Tel: 01895 250230
Case Officer: James Wells
Email: JWells@hillingdon.gov.uk
Date: 17th May 2022
Our Ref: 77137/PRC/2022/58

RE: Creation of a box van loading/delivery bay, new landscaping and extension of the car park to create 11no. additional car parking spaces

SITE: Rabbsfarm Primary School Gordon Road Yiewsley

Date: 03 March 2022
Scale: 1:250@A3
Source: AutoTrack
Drawing No. P2571/TS/03

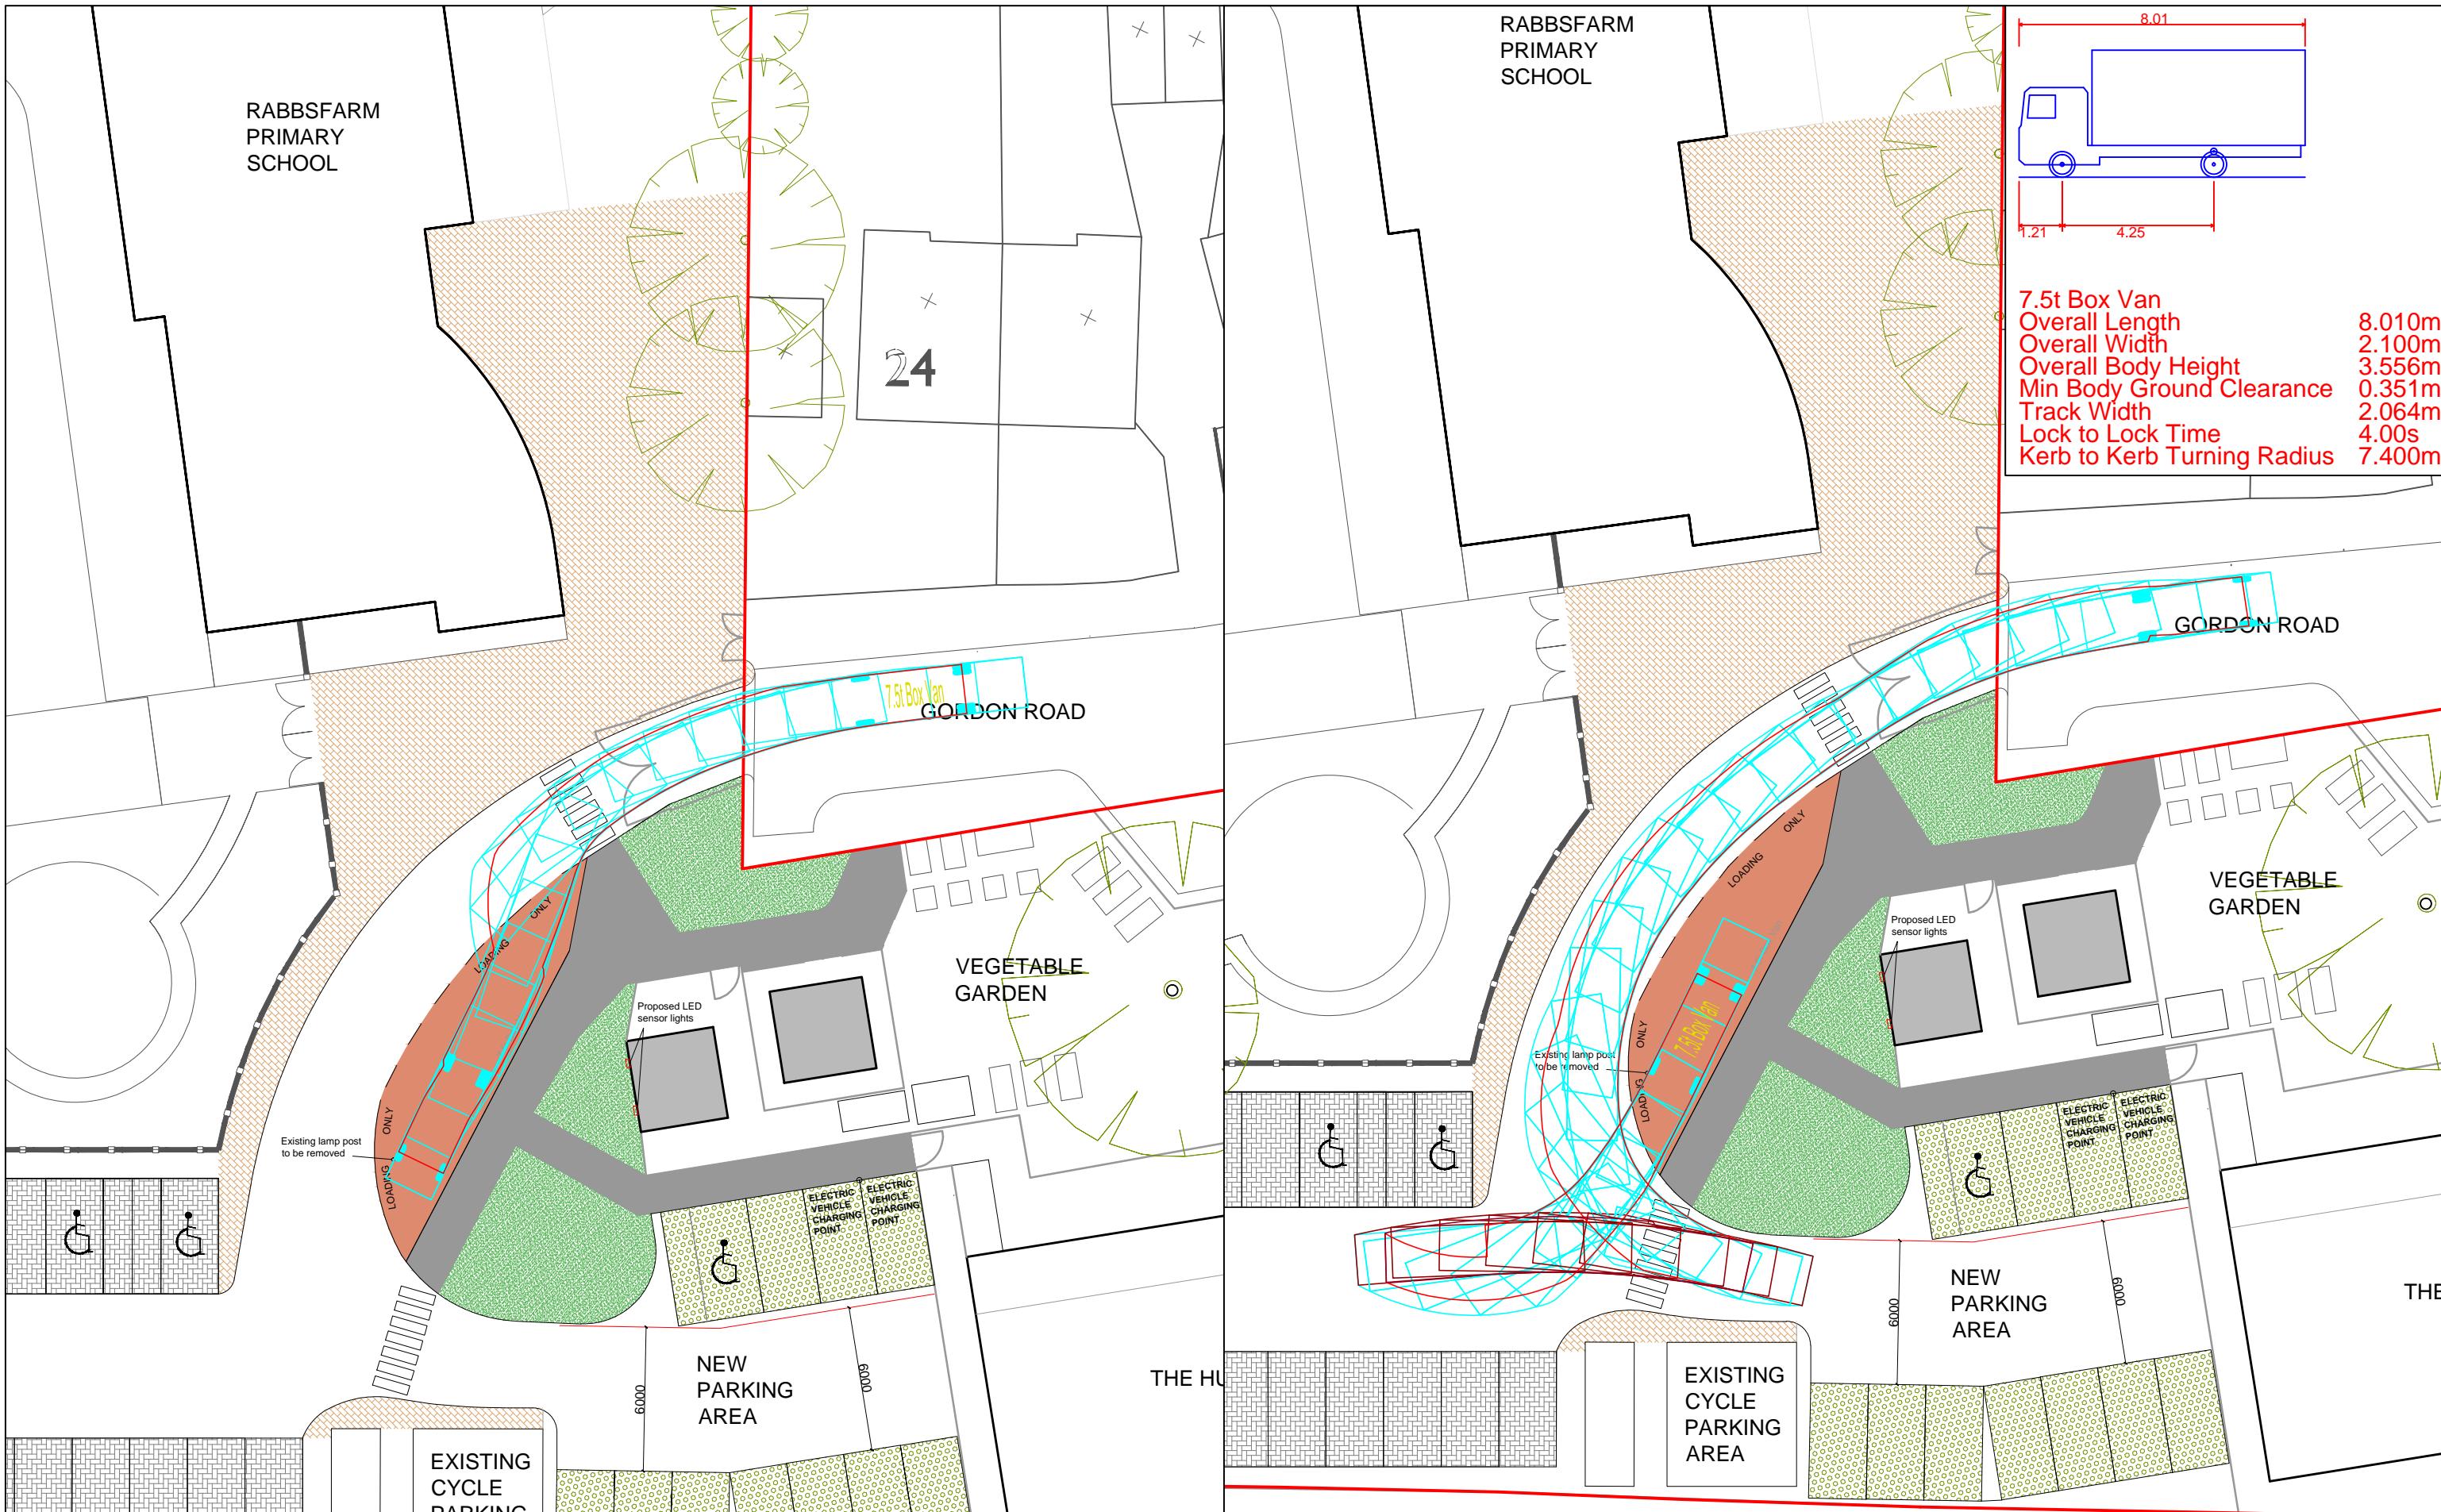
The Highway Authority requires that the dimensions of parking spaces, carriageway and footway widths, pedestrian visibility splays and cycle bays, etc., should be shown and annotated on the deposited plans. Copies of all plans should be provided printable to scale at A3 drawings. Tracking drawings would be required to demonstrate that a vehicle entering the site can turn and leave in a forward gear.
